Application No: FG/37/22/PL
Site Address: 61 Sea Lane Gardens Ferring BN12 5EG
Description of works: 1 No dwelling. This site is in CIL Zone 4 and is CIL Liable as new dwelling.

Thank you for your internet representation made on 6th April 2022 which has been recorded as an objection with the comments as follows:

Ferring Parish Council object to this infill application due to overdevelopment of the site and highway safety concerns.

# PROPOSED CAR PARKING PLAN 1:50

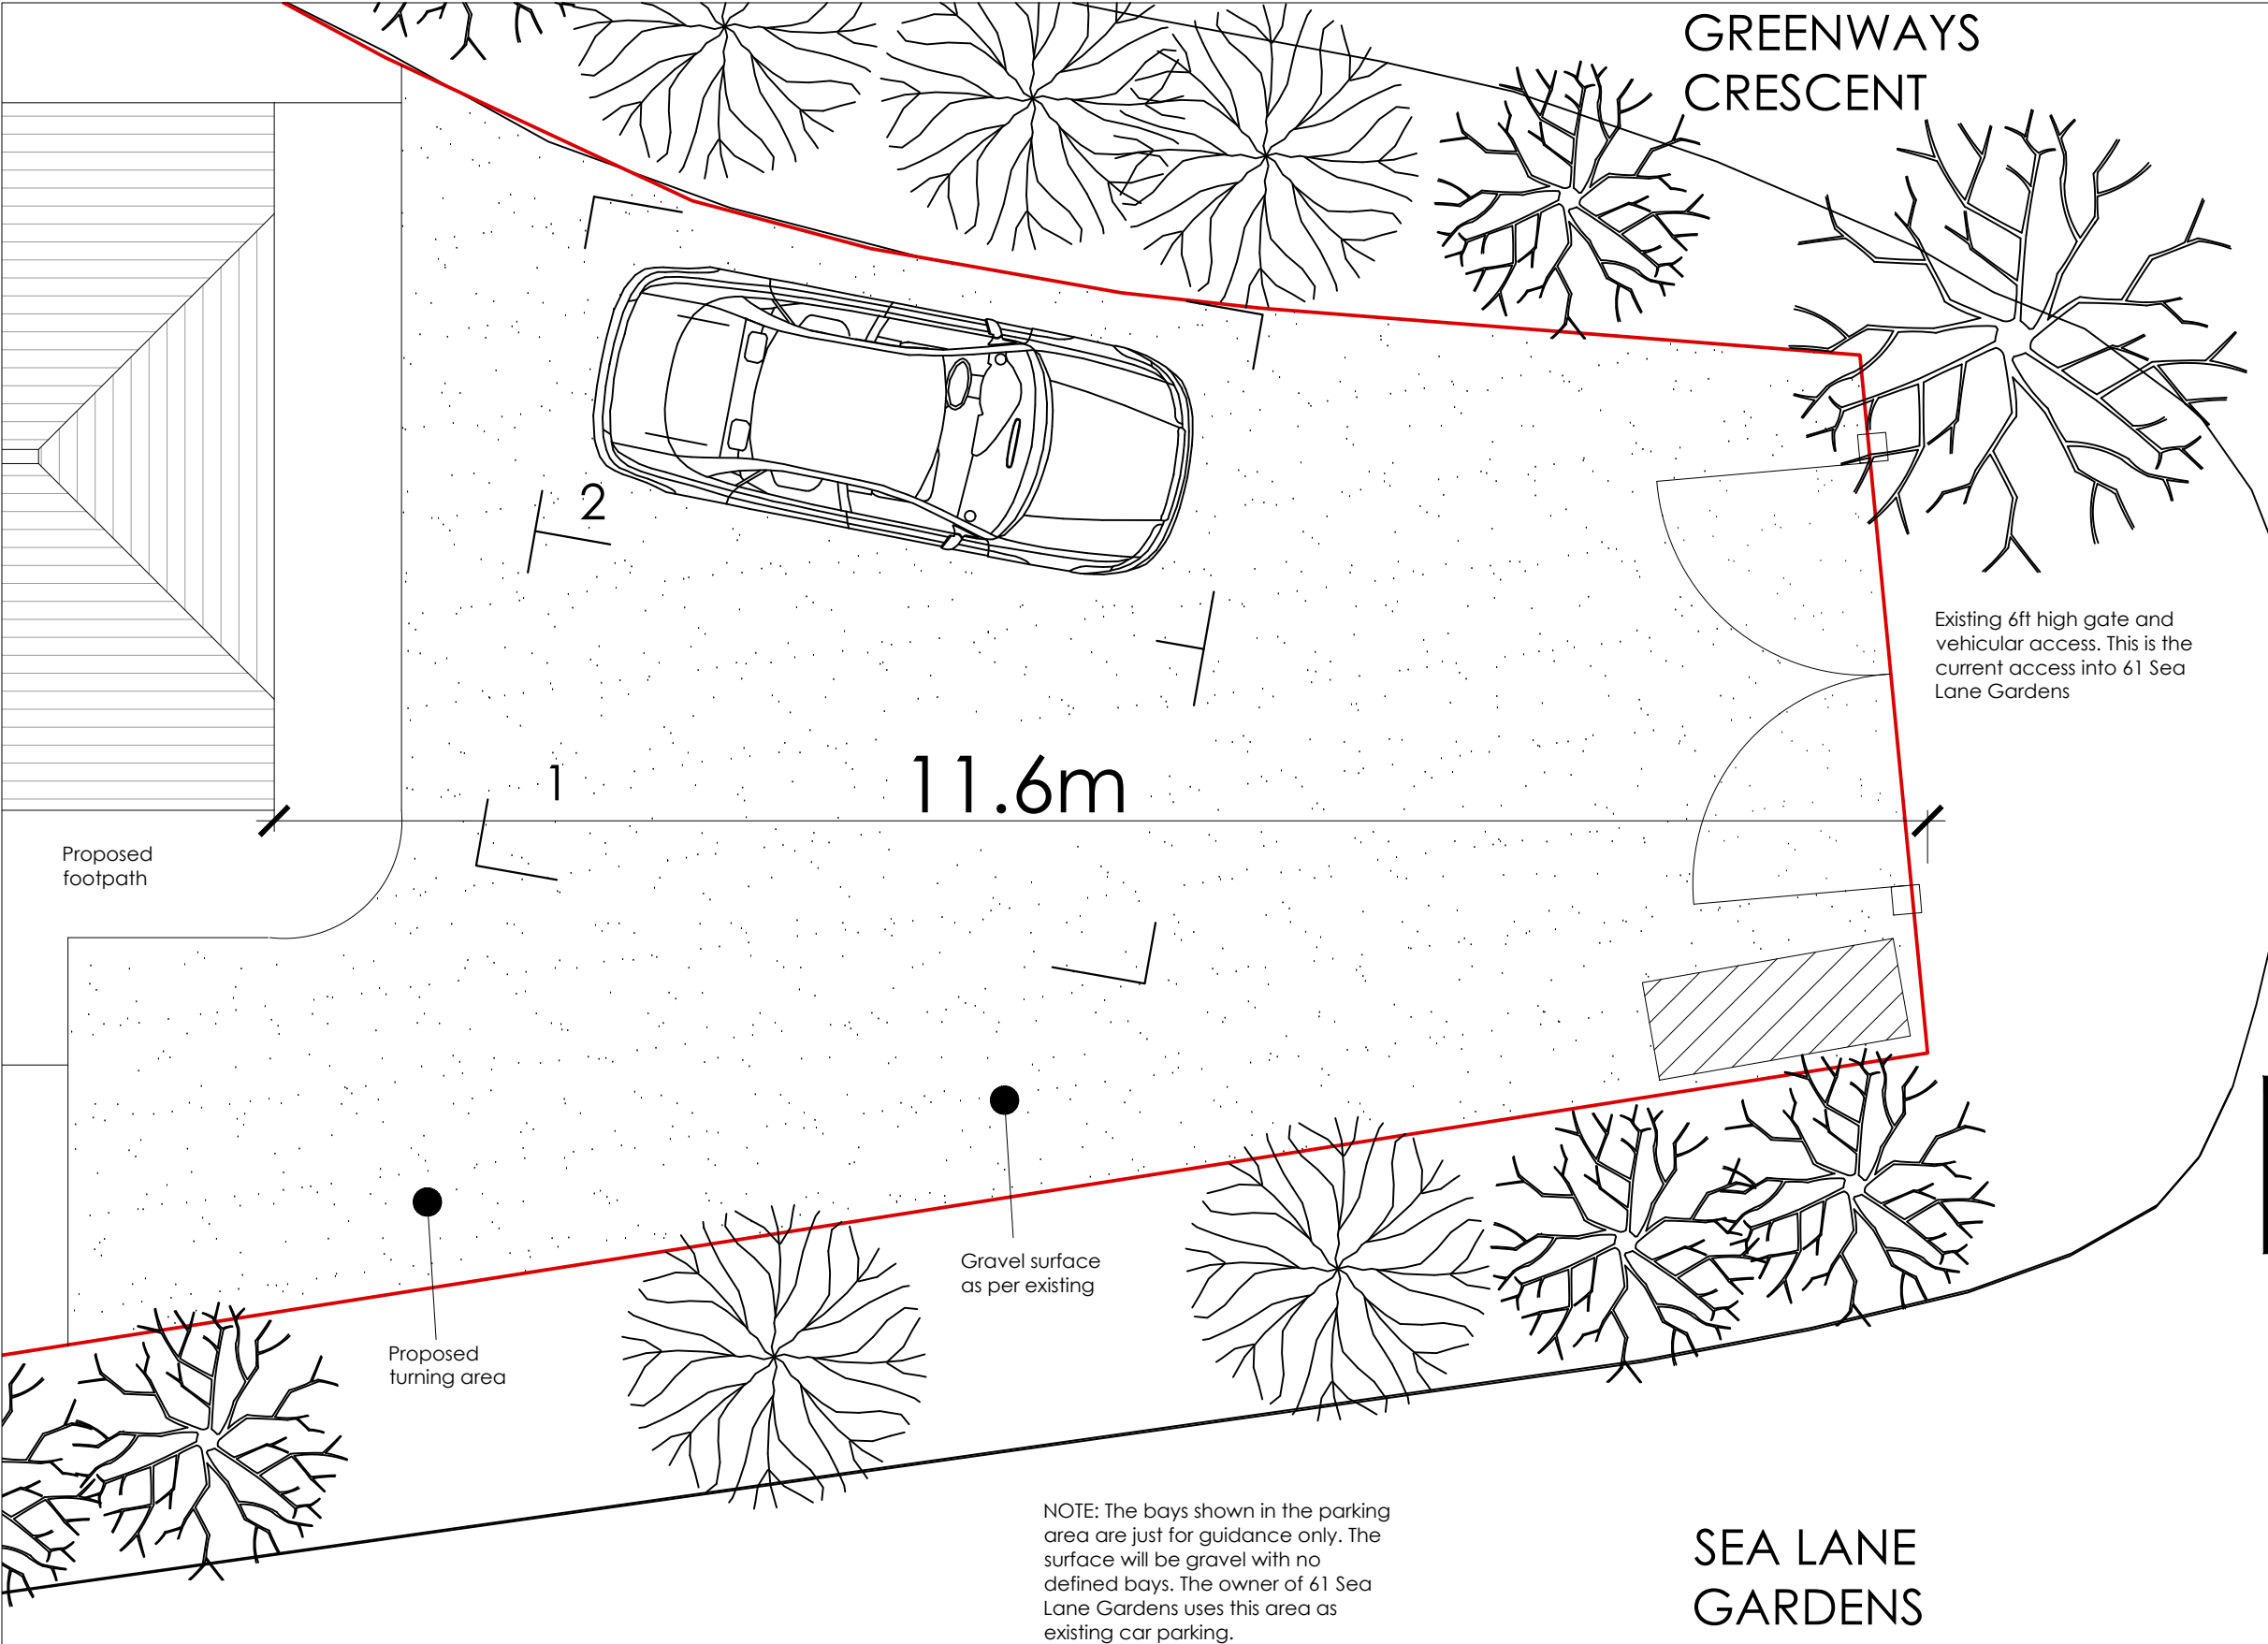
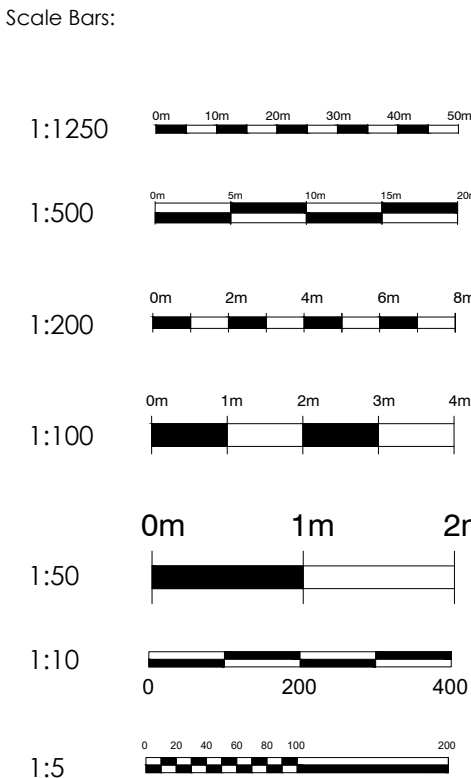
Vehicle access/egress is by an existing driveway emerging directly onto a sharp junction with restricted visibility. While WSCC Highways have given that they consider that the implications may not be 'unacceptable' or 'severe' and that 'A turn on site may be possible with the use of a multi-point manoeuvre', it does raise serious concerns by neighbouring residents and this parish council. Due to the restricted visibility for any vehicle attempting to reverse out of this site and other vehicles on the highway at this junction this would present an unacceptable risk. This existing risk is compounded by the proposed overdevelopment of the site severely reducing onsite parking and turning ability.
